From: Chris Niederman <Chris@niederman.com>
Sent time: 06/01/2021 03:24:45 PM
To: Jeromy Hicks
Subject: Re: Gate Permit 2105-227
Attachments: 2105-227-SUB1-PLANS-DENIED.pdf NIEDERMAN ENTRY GATE LOCATION - TERRANE SURVEY FROM CITY APPROVED
RENOVATION PLANS copy.pdf

From: Jeromy Hicks <jeromy.hicks@mercergov.org>
Date: Tuesday, June 1, 2021 at 2:43 PM
To: Chris Niederman <Chris@niederman.com>
Subject: Gate Permit 2105-227

SHEET NUMBER
SK-1

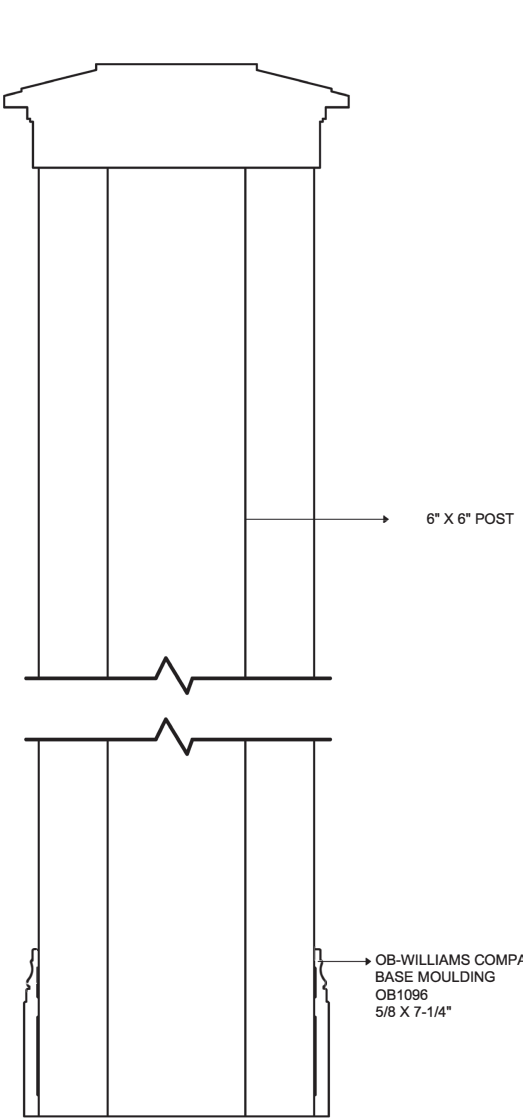
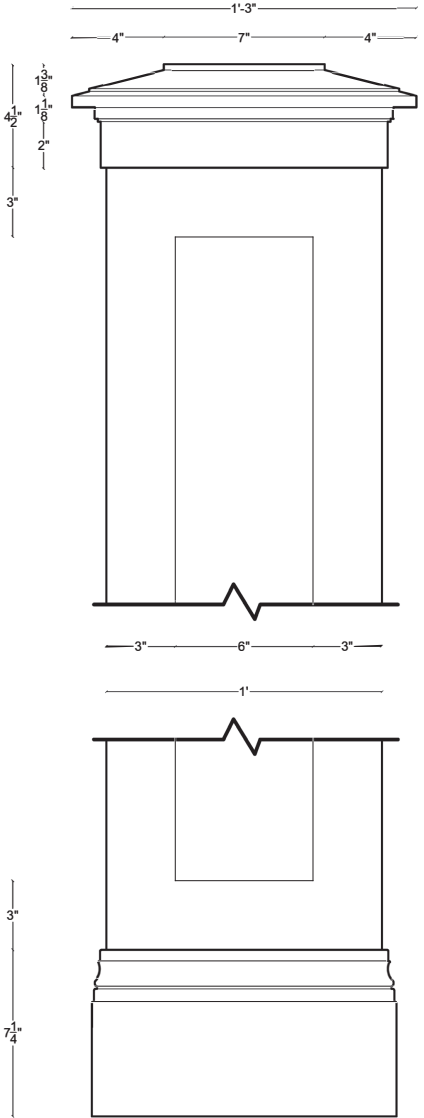
I agree with the width, but will need to know where this is being placed. My assumption is on the property (minus setbacks) and will be constructed to open inwards. Additionally I will need to know the opening mechanism, battery back-up, fail safe open when power is out, UL standards, and the access method you are choosing. If it is 'Click to Enter' then great.. if not I need it noted on the plans were the pedestal or Knox Switch will be located.

2/ Gate Location (page 4) – please refer to the attached Terrane survey from our City approved permit when we did our recent home renovation. I think this has all the information you need regarding showing the paved driveway meeting the access road, etc. The location is marked by a black circle. The gate will be on our property, but I'm not clear on the setbacks needed for such gates...where do I find that information or will the gate company know?
